Rezoning Transportation Analysis

Petition Number: 2020-122

Reviewer: Eric Lemieux, PE

Date	Description
09-14-20	First Review

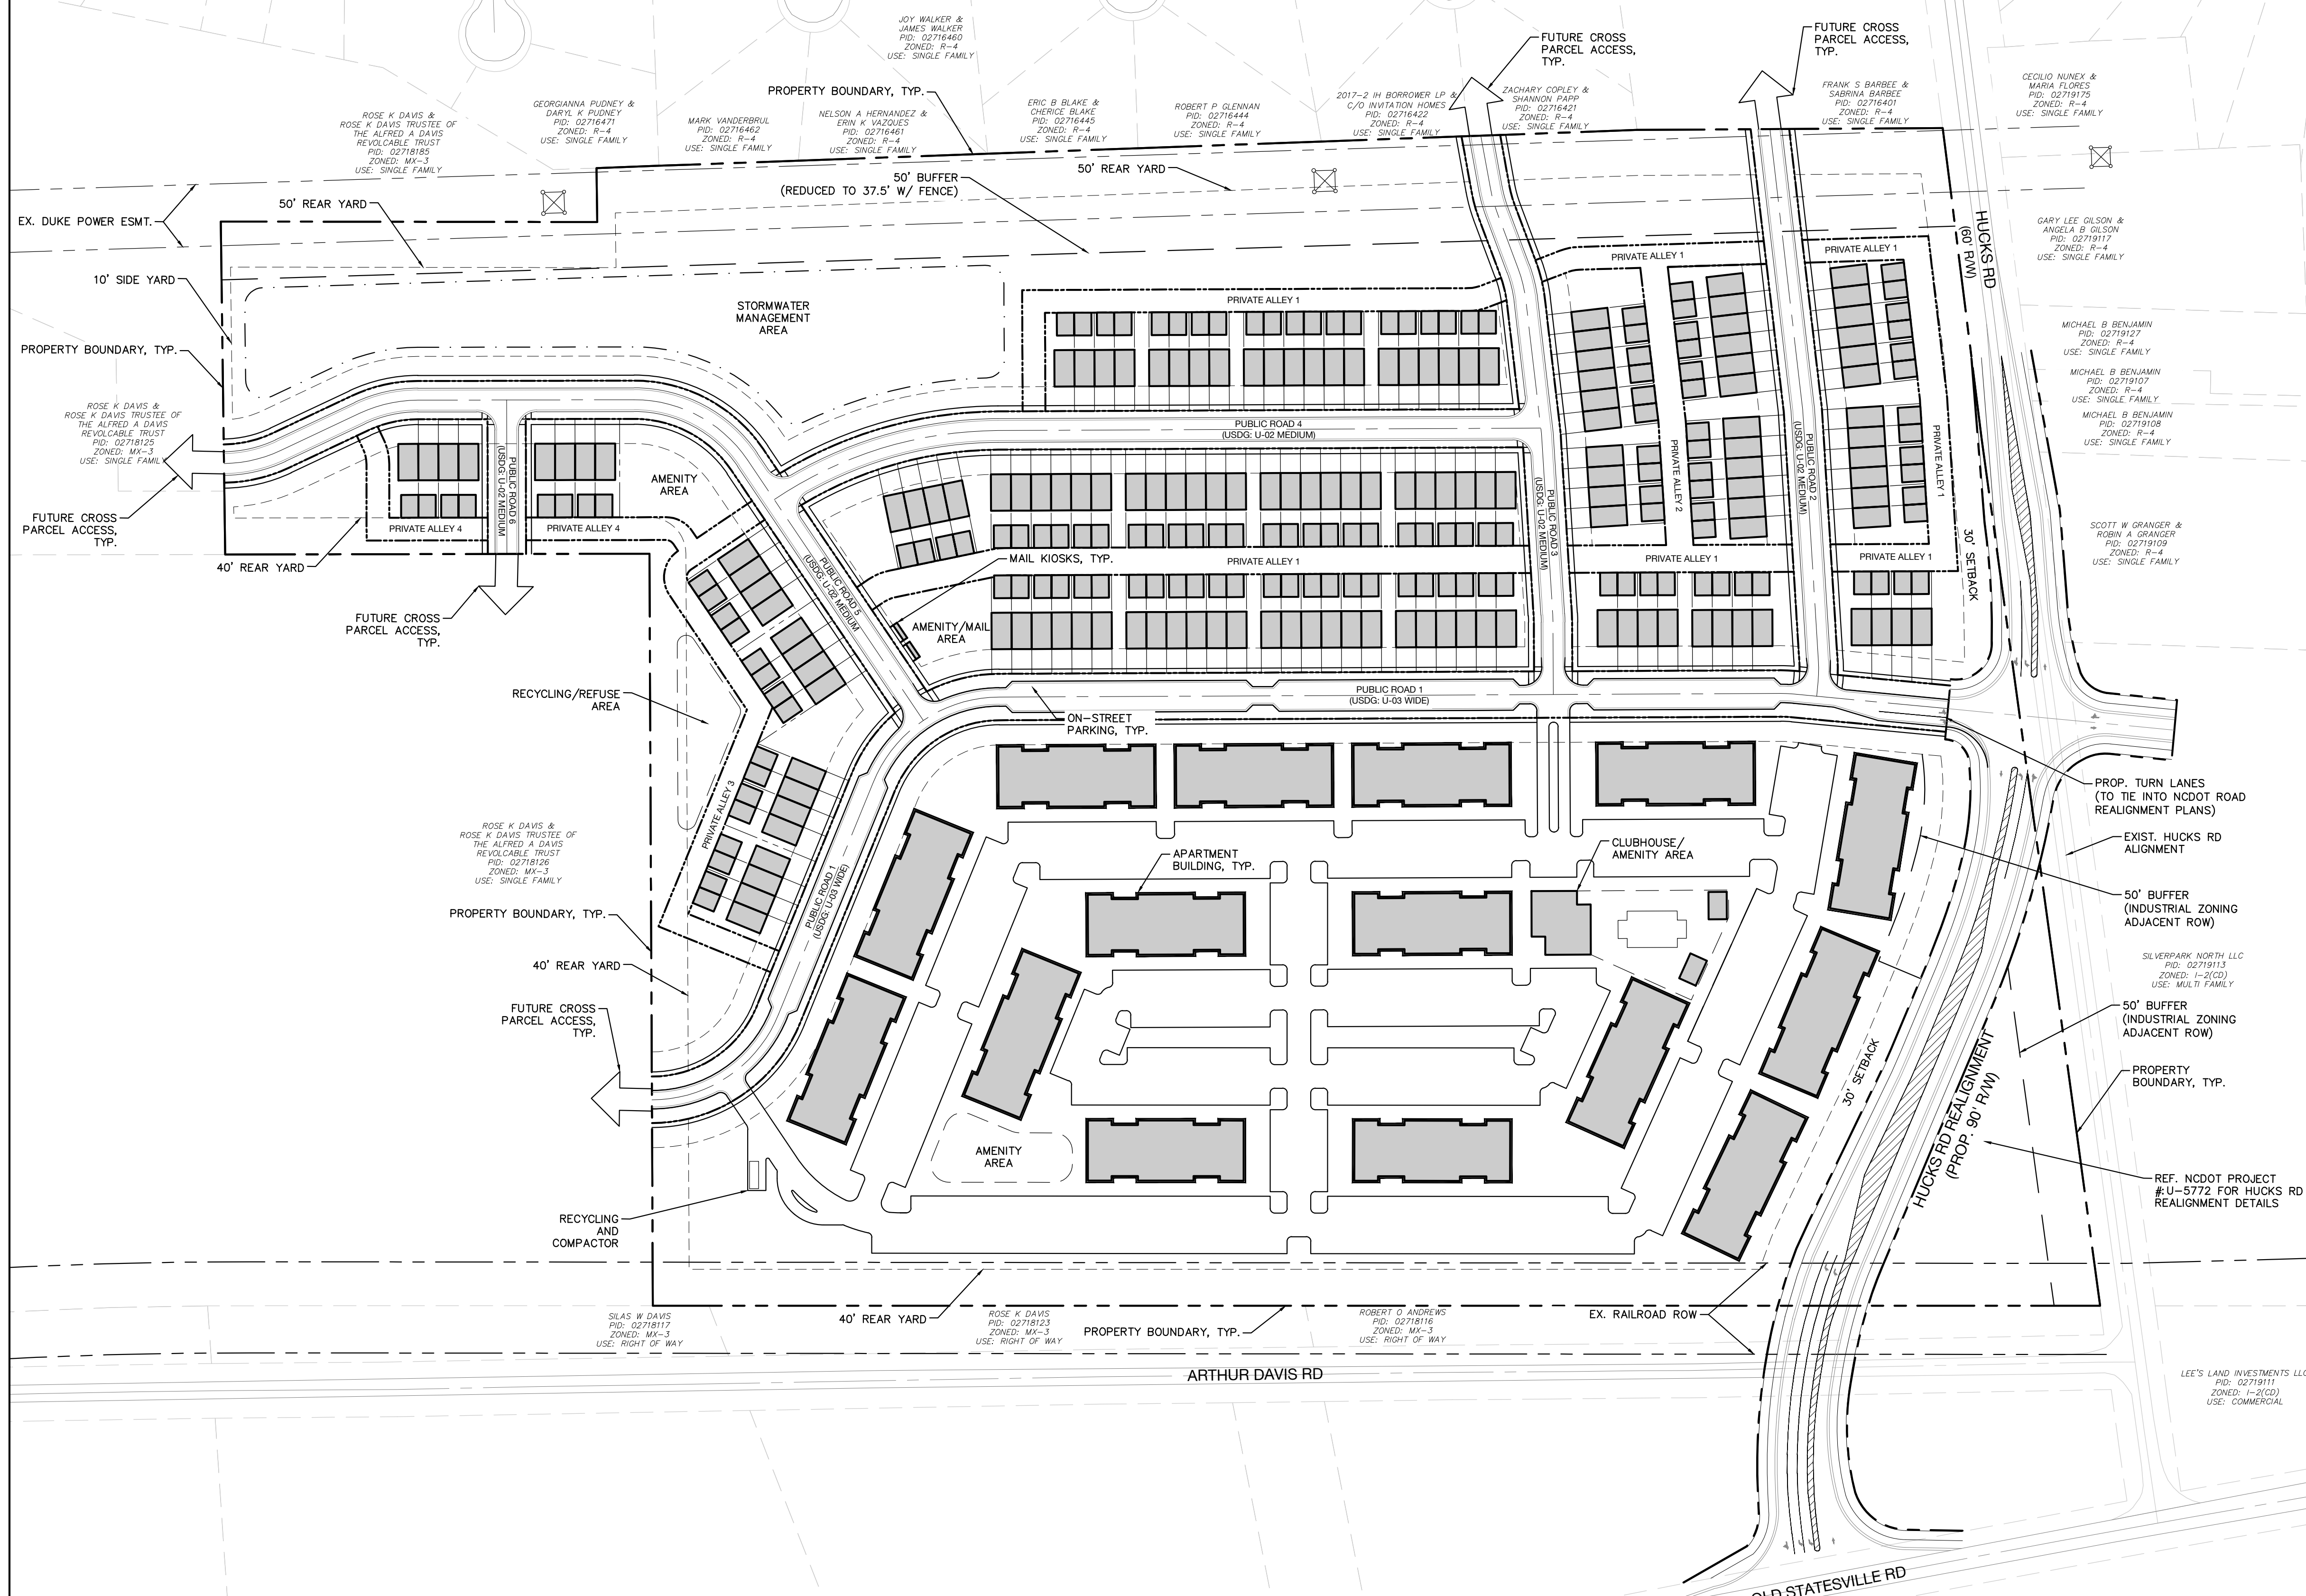
4. Revise the site plan and conditional note(s) to commit to construct the portion of Hucks Road Realignment that is graphically depicted on the site plan sheet **RZ-1.0**, to match the approved TIS scope.
